From: Giles Cheetham
Sent: 11 August 2016 18:20
To: 'Michael Powell'; Farzana Tabasum
Cc: Malcolm Joy; John Brooks; Alistair McMurray; Highways DevelopmentControl
Subject: RE: 2016/60/92298 - North Bierley WWTW - PRoW matter

[RE: 2016/60/92298 - North Bierley WWTW - PRoW matter](#)

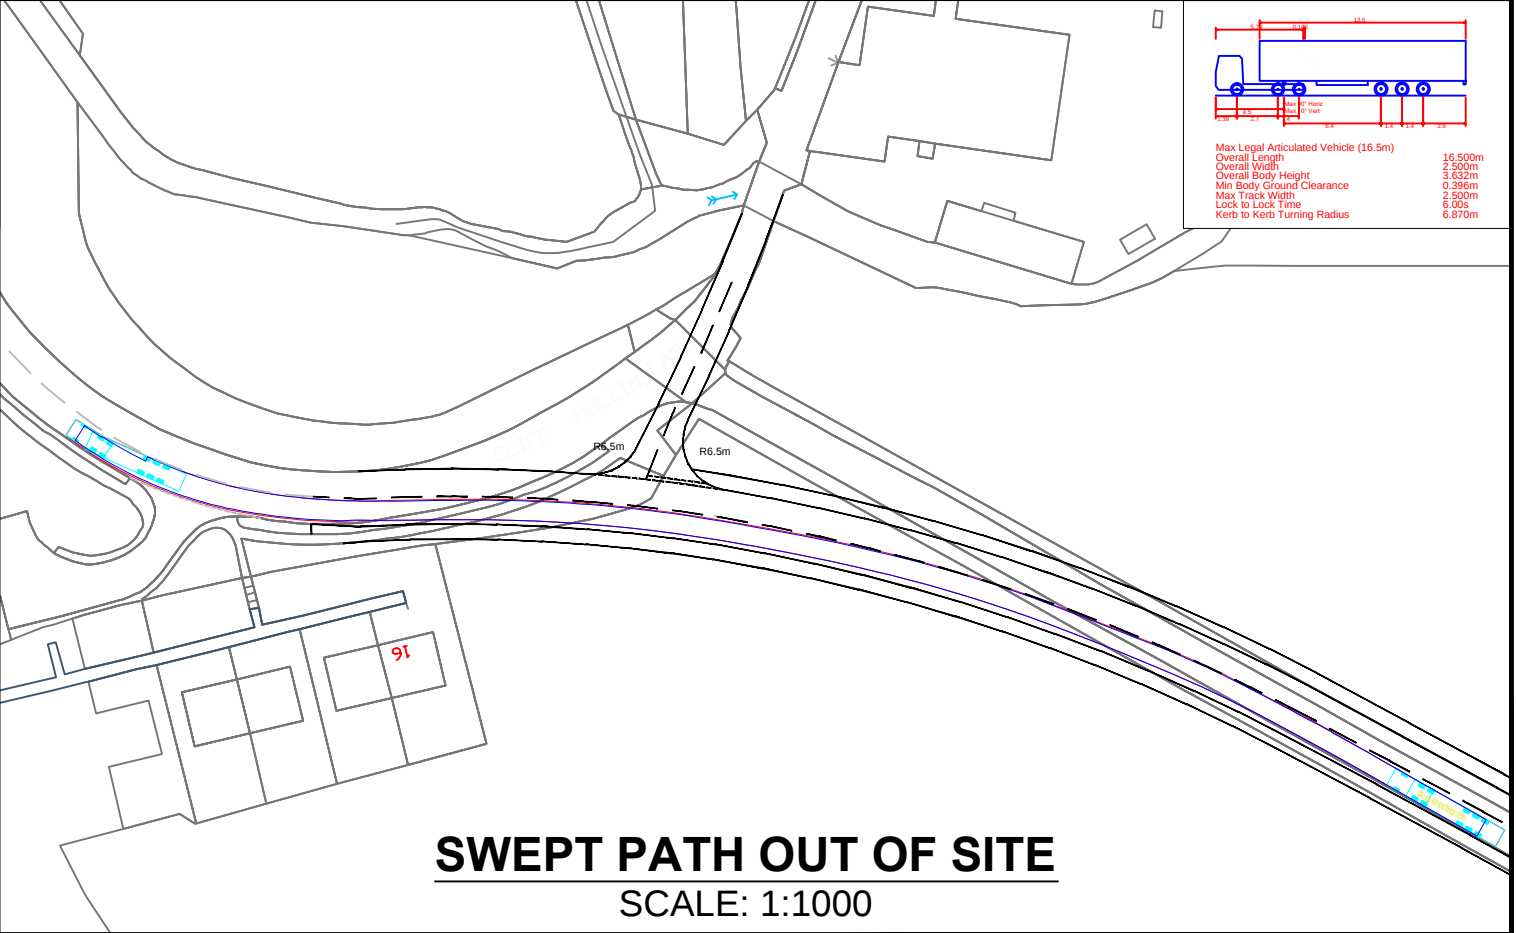
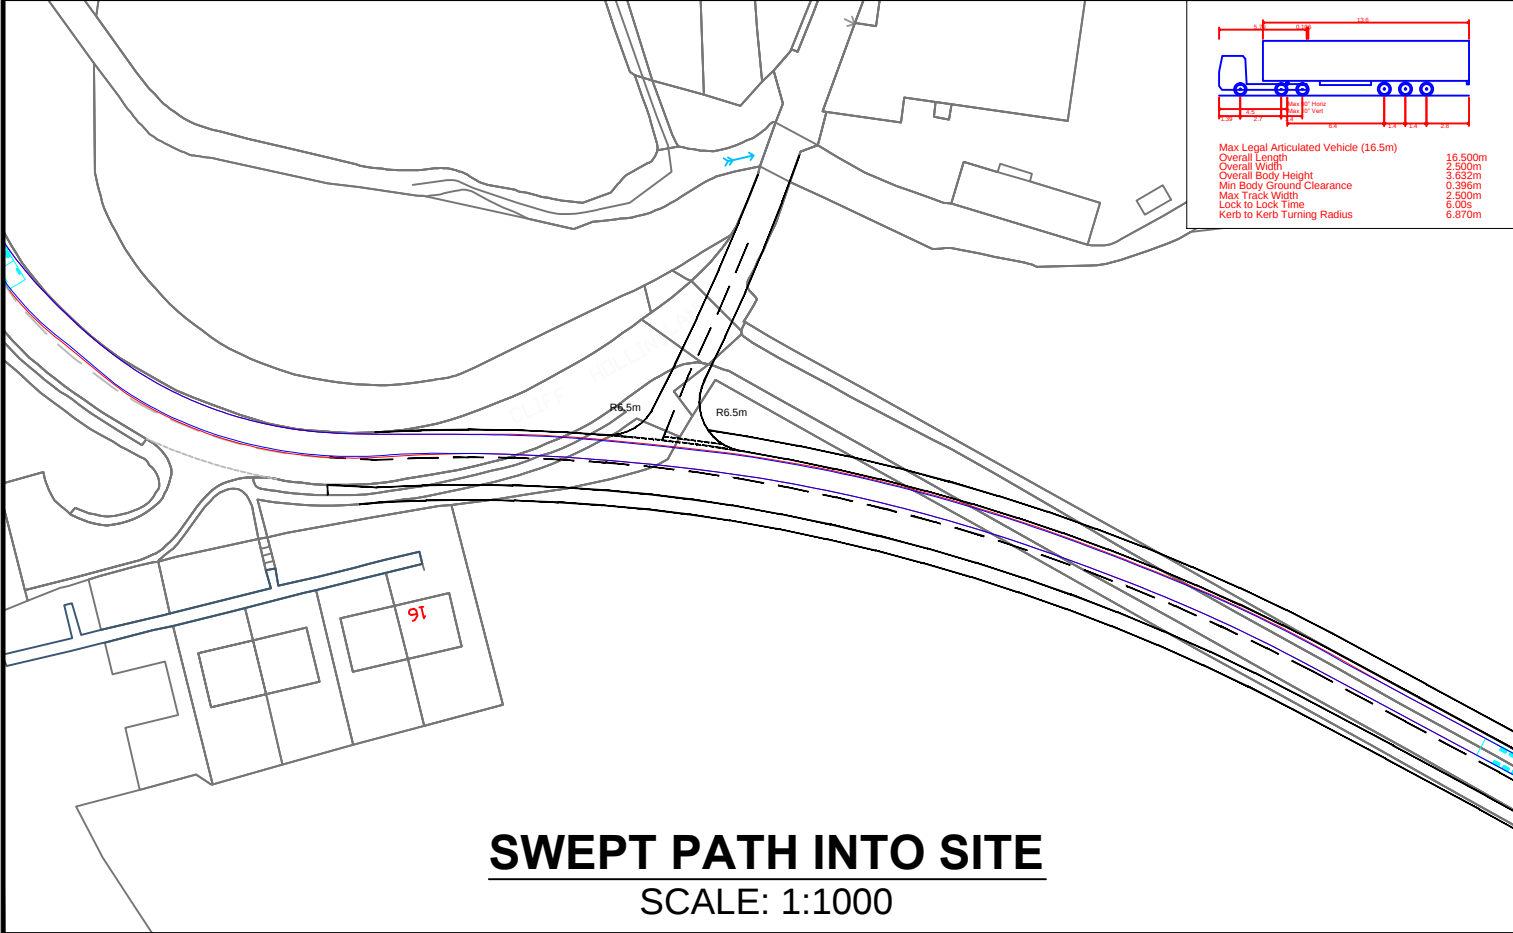
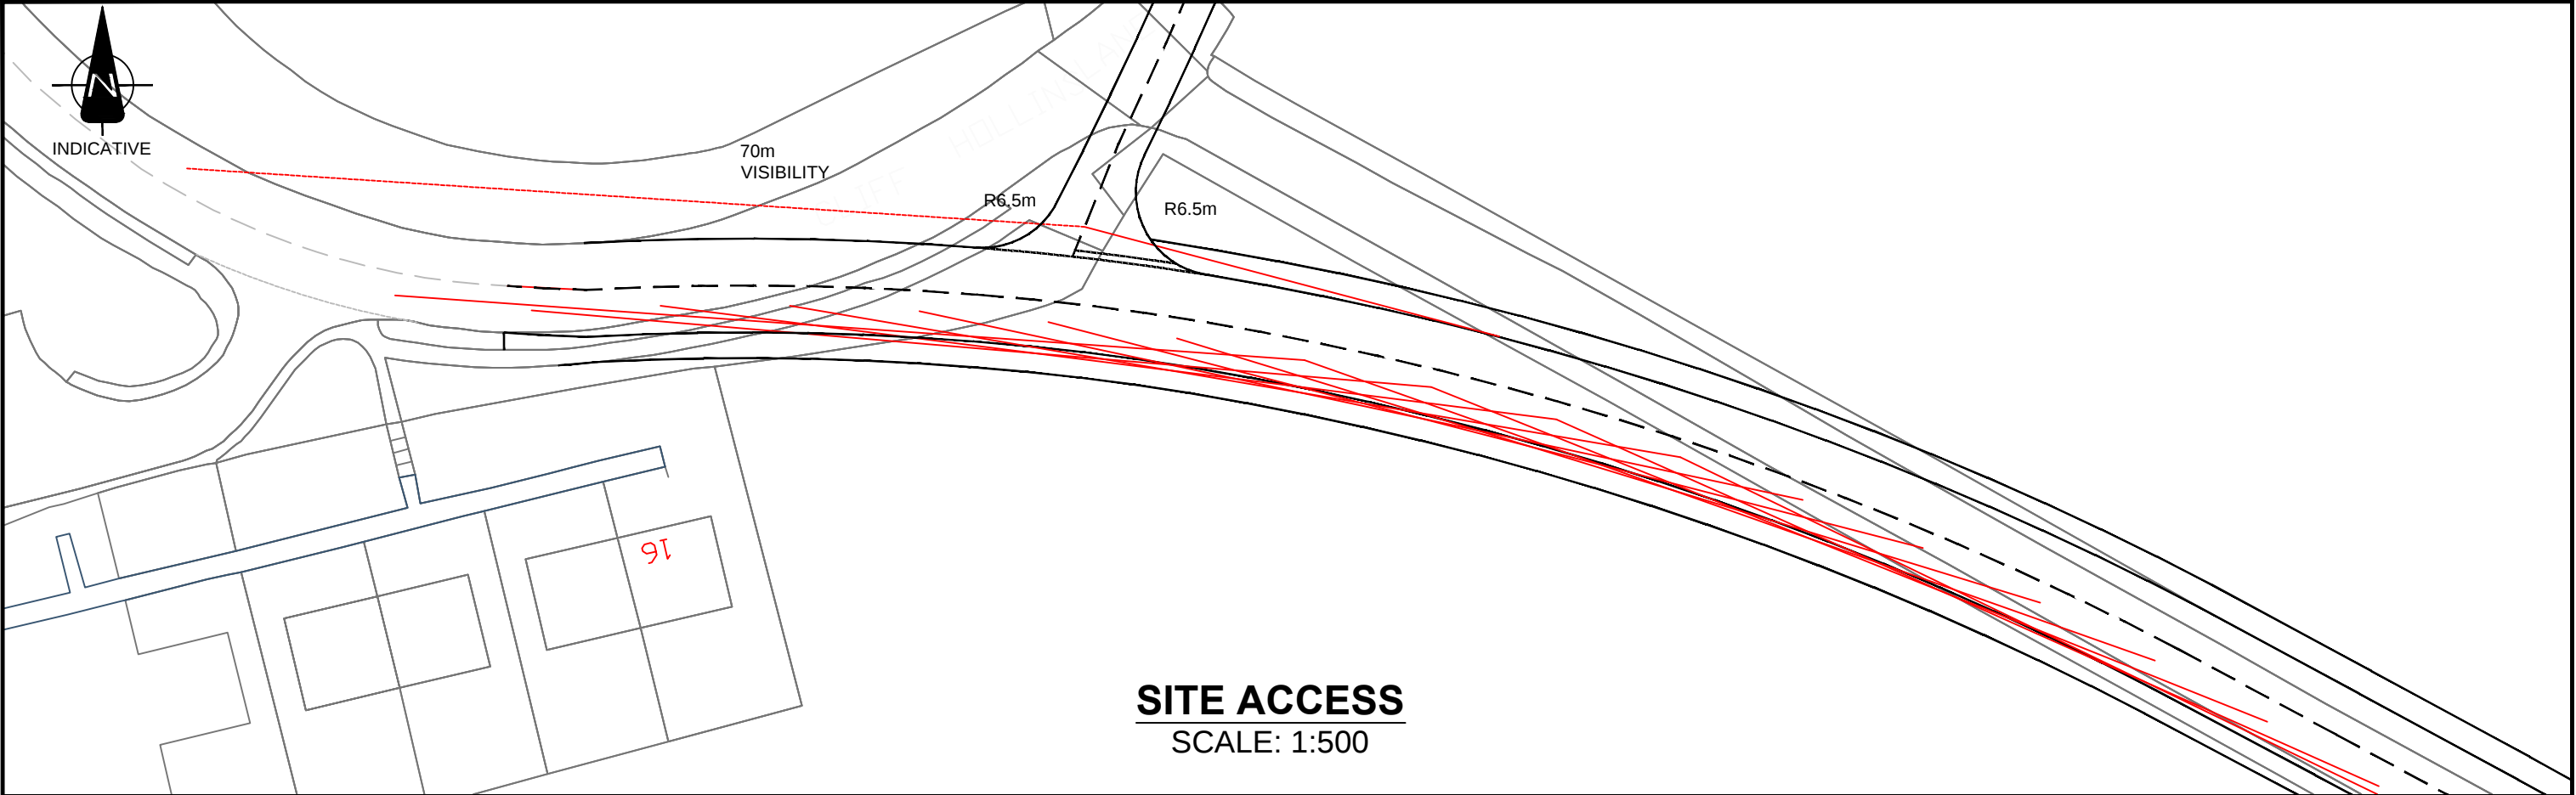
The application submissions did not refer to the PROW and do not demonstrate that it has been considered at all.

PROW has objected to the application as made, as you know.

This situation can potentially be easily addressed by the applicants making appropriate formal planning submissions considering the existence and treatment of the public footpath. At the least, I consider that the feasibility should be demonstrated even at this outline stage by amended or additional submissions.

As this matter may move forward over different stages, I would note that an appropriately constructed, separated public footpath, away from any carriageway and footway would be sought by PROW, so that it is not incorporated into the estate road layout. This may result in a distinctly different indicative layout for the estate road, unless the applicants intend to engage in the formal public path order process, which may add expense and significant delay to their project.

The alignment of the existing access road is to be retained in part. However, a new alignment is proposed where it joins Cliff Hollins Lane, which will be widened along most of its length.

Given that the planning application is made in outline, with all matters reserved, there is no requirement on the application forms to make explicit reference to the PRoW. Further details on the PRoW will be provided and determined through subsequent applications for the approval of reserved matters.

A segregated footpath or footway is proposed on the edge of the carriageway. Both of these options improve the current shared pedestrian/vehicle use of the access, but the applicant would be open to discussion in this regard. We would be happy to work with the LPA to provide a new route to an improved standard.
